From: Anita Gardner
Sent: 20 December 2018 14:25
To: Planning.Responses
Subject: FW: FG/171/18/DOC - Peugeot Garage Premises, Littlehampton Road,

Subject: Re: FG/171/18/DOC - Honda Garage Premises, Littlehampton Road,

Environmental Health: Application for discharge of conditions. Further information required.

Construction Management Plan

DRAWING TITLE
Proposed external lighting scheme

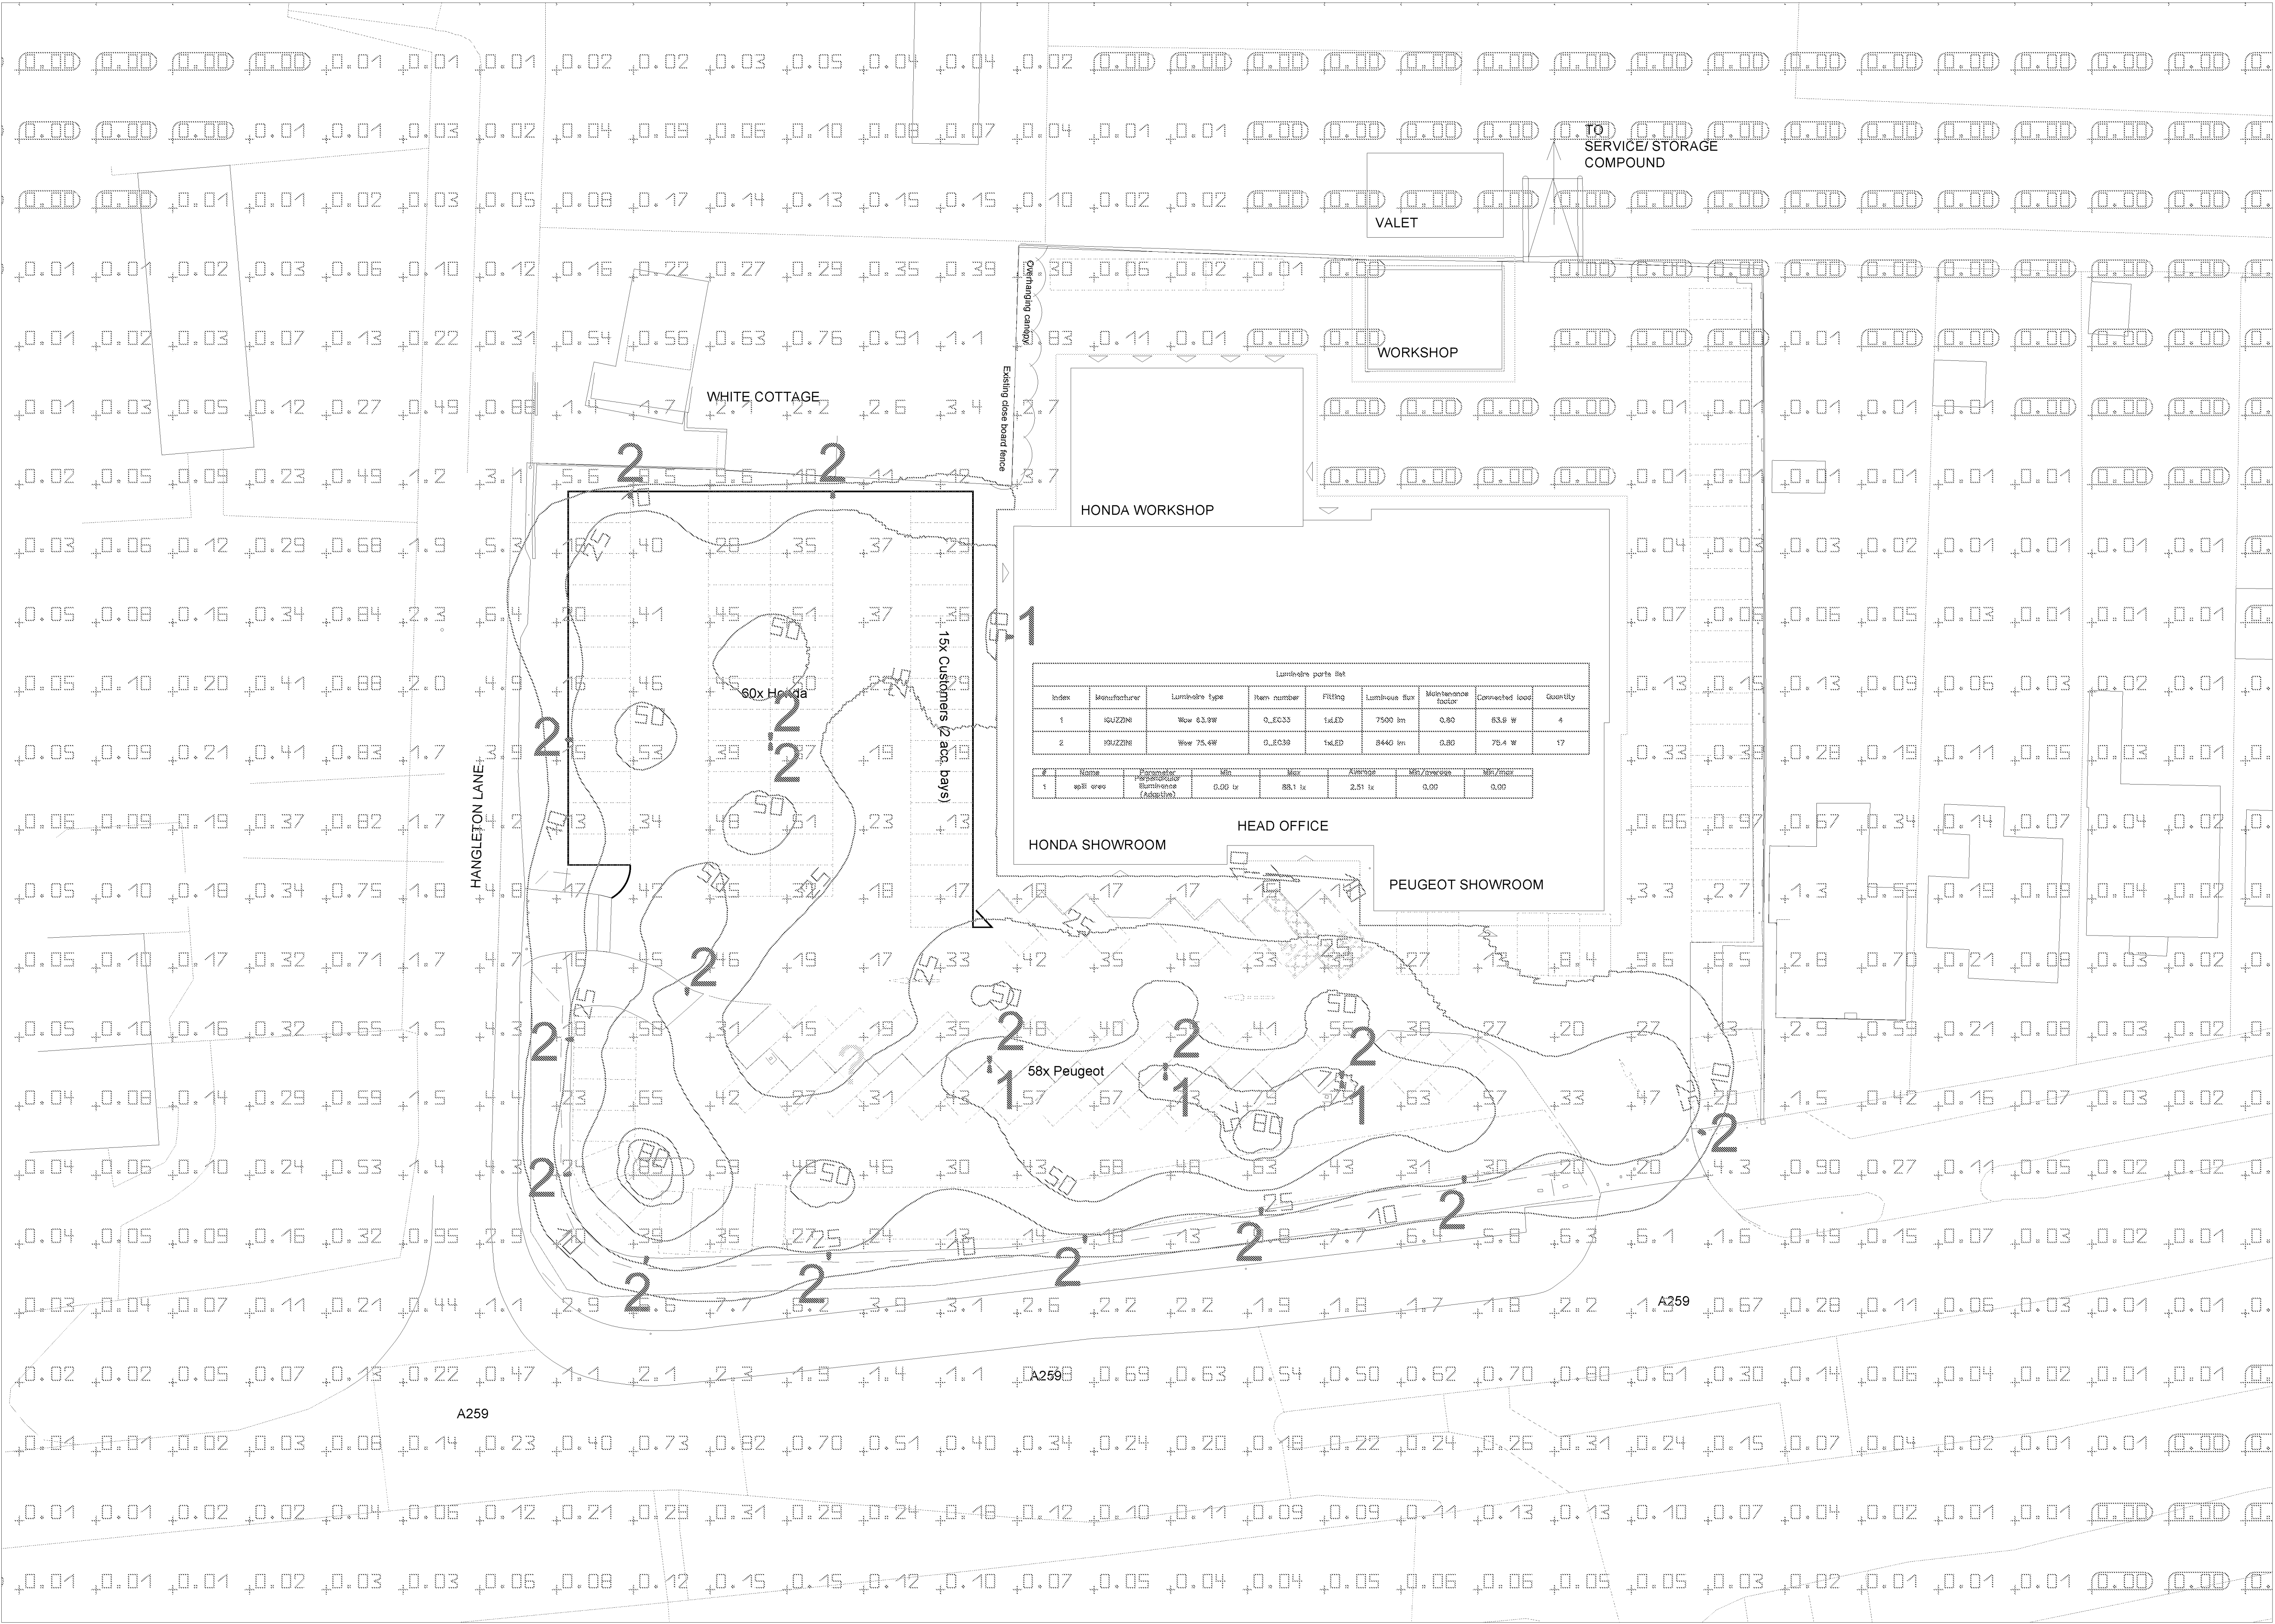
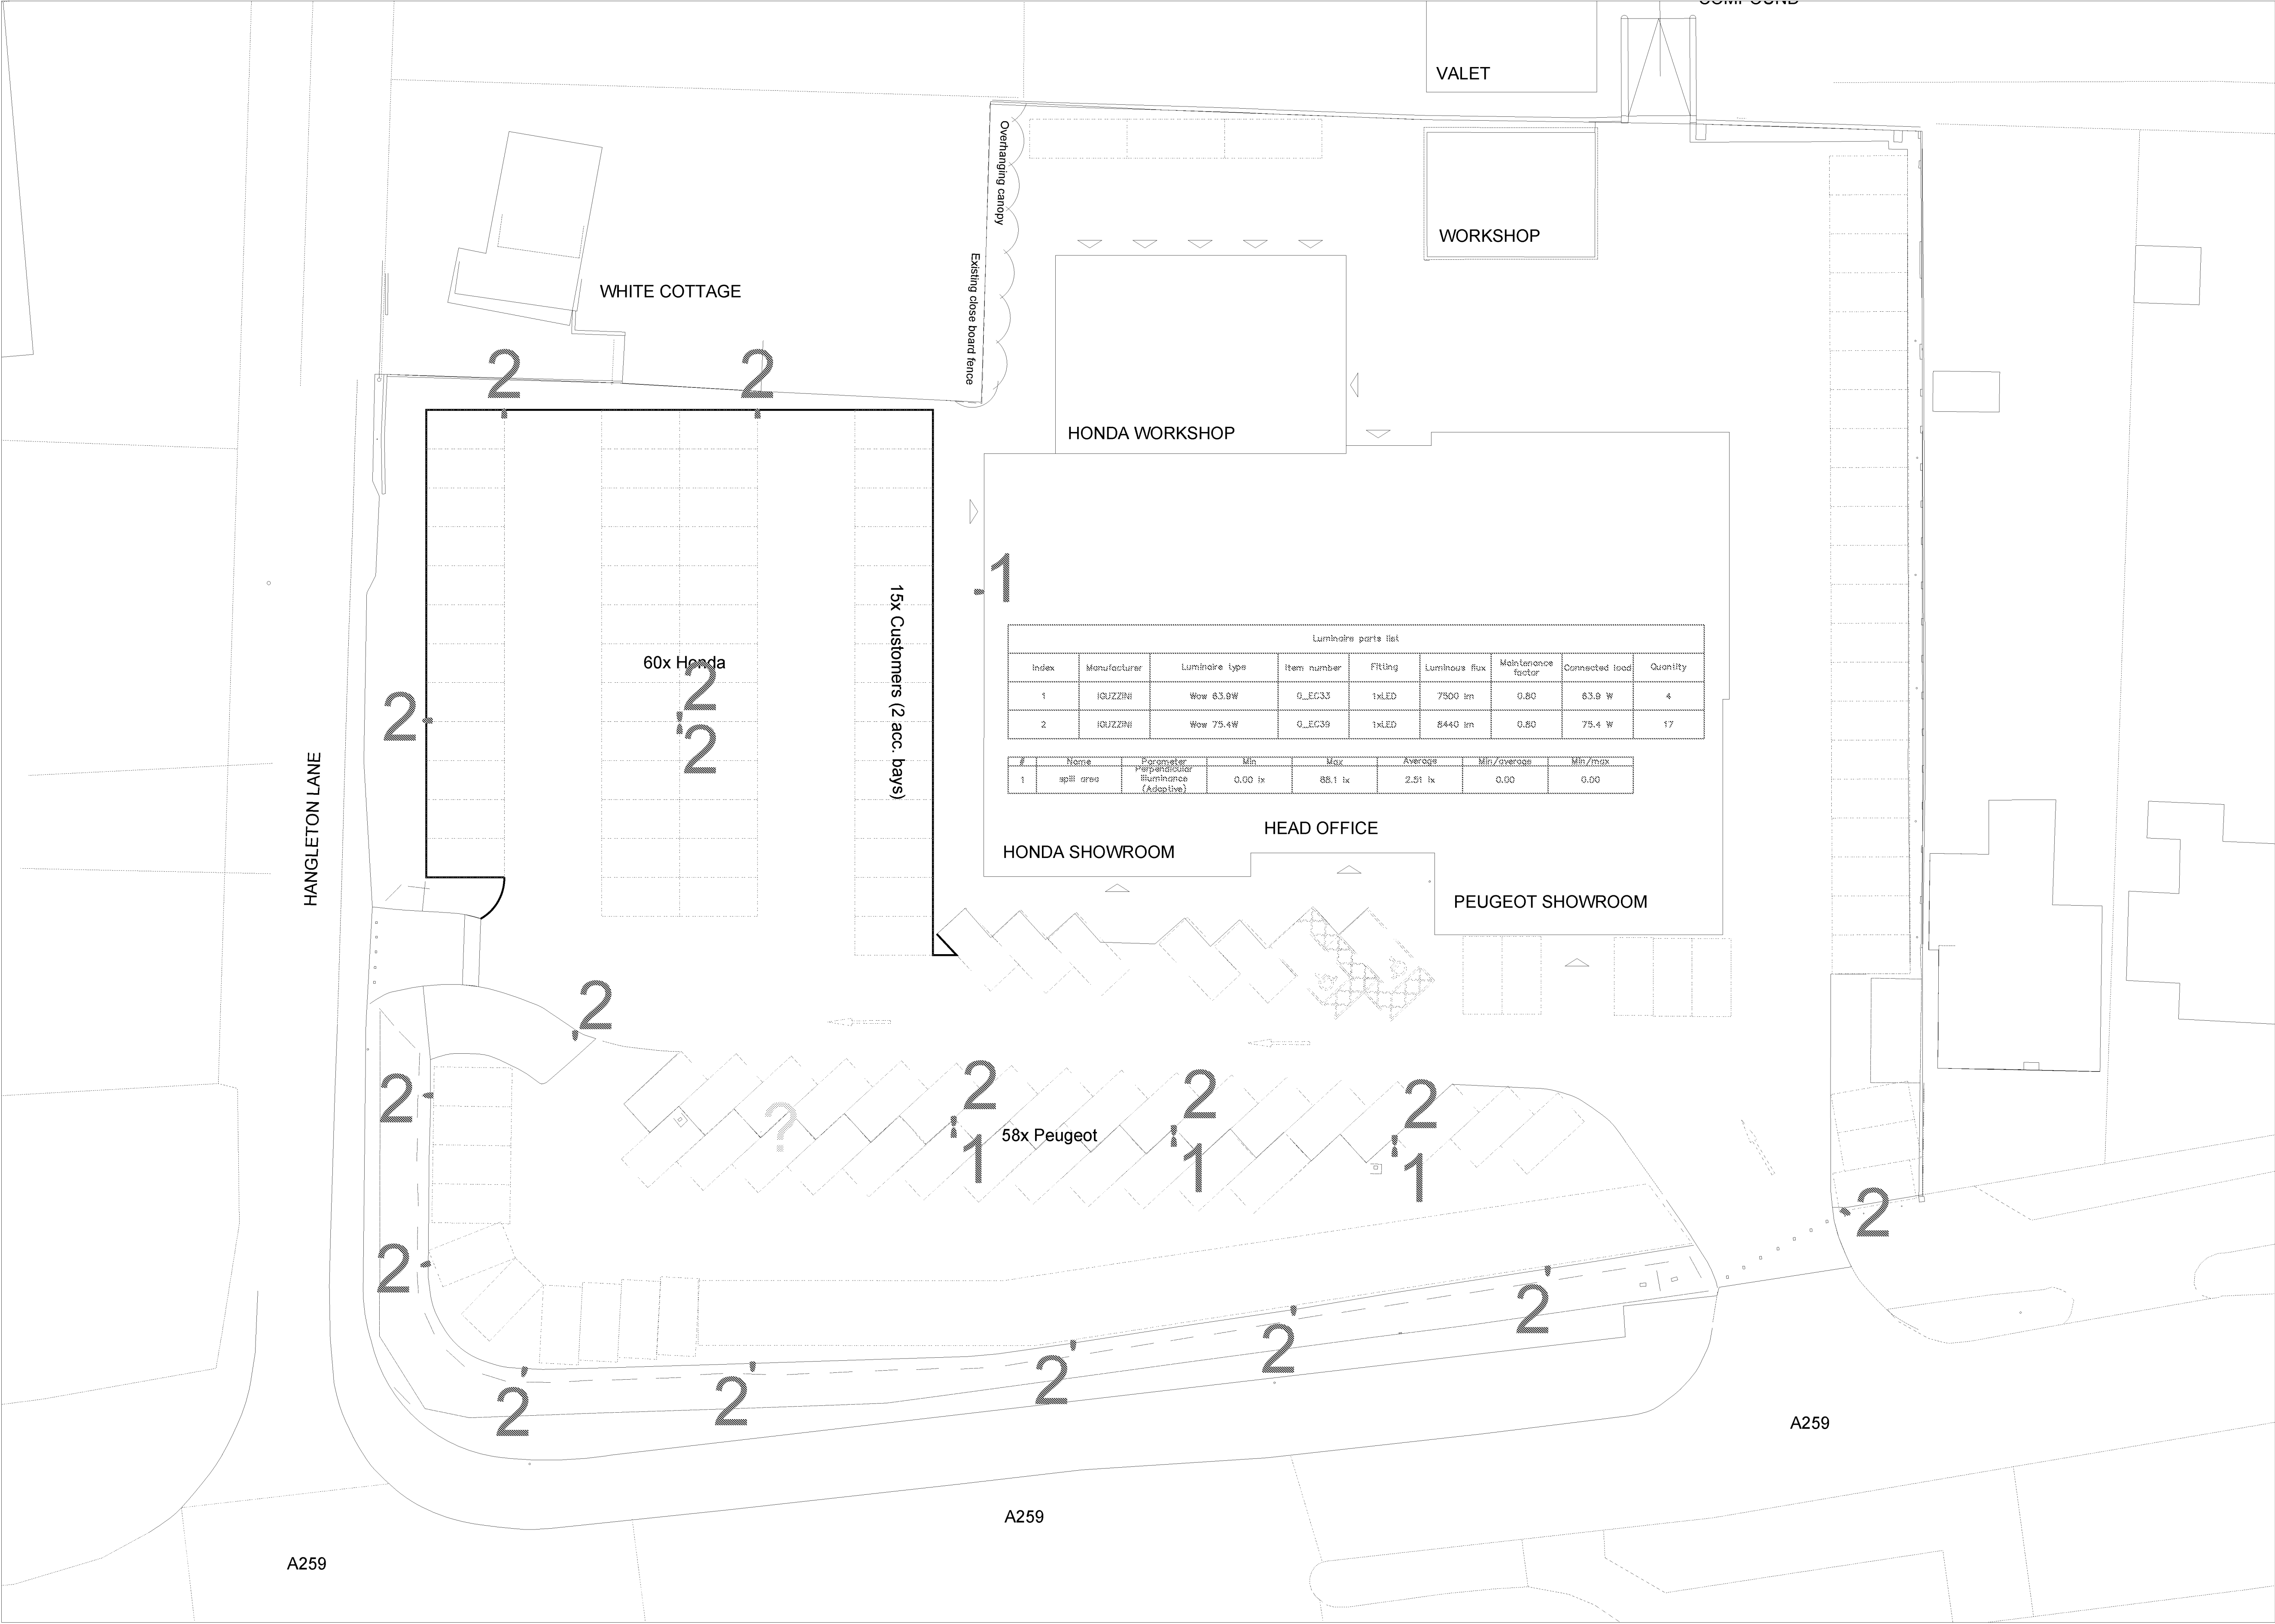
Lighting Plan: Lower level lighting, specified as 'Type 1' to be provided to areas proximal to sensitive receptors and to the north of the site in order to prevent detriment to the amenity of these properties and South Downs National Park.

I understand that our electrical engineer will contact the EH officer on her return from leave on Monday to discuss the external lighting design comments further. Hopefully to a resolution asap.
